From: [Justin Turnbull](#)
To: [Zach Torrance-Smith](#); [Jackie Sharp](#); [Rebecca Cruse \(PW\)](#)
Cc: [Jamey Ayling](#); [Ellie Myers](#); [Sam](#)
Subject: RE: BL-23-00025 Graham - Updated Survey
Date: Tuesday, February 11, 2025 8:32:01 AM

Subject: BL-23-00025 Graham - Updated Survey

If Justin could please review the attached updated survey for BL-23-00025 Graham, that would be very helpful. This project was given CPA all the way back in November 2023.

RECORD OF SURVEY FOR BOUNDARY LINE ADJUSTMENT LOT 12, BLOCK 4 AND LOTS 7 & 8, BLOCK 5, PLAT OF SOUTH EASTON WITHIN THE NE 1/4 OF THE NE 1/4 OF SECTION 14, TOWNSHIP 20 NORTH, RANGE 13 EAST, W.M., KITTITAS COUNTY, WASHINGTON

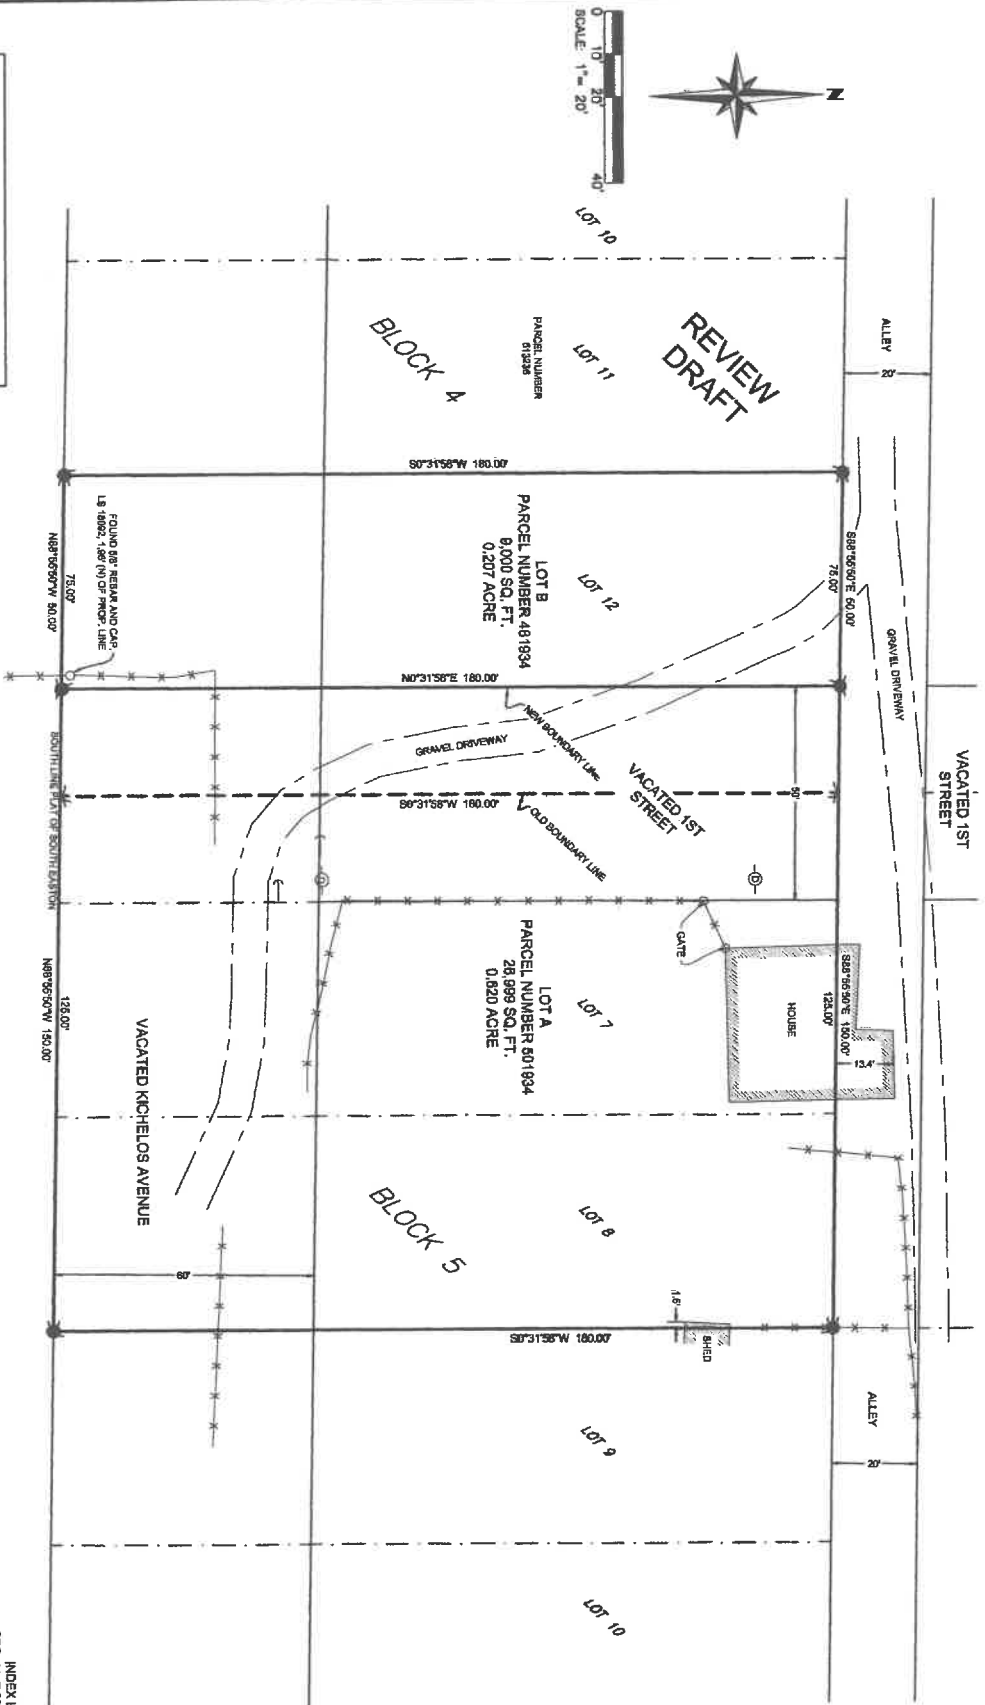
Please double check dimension label text heights prior to filing. They appear small, but I as I review plans at a reduced size, can not verify.
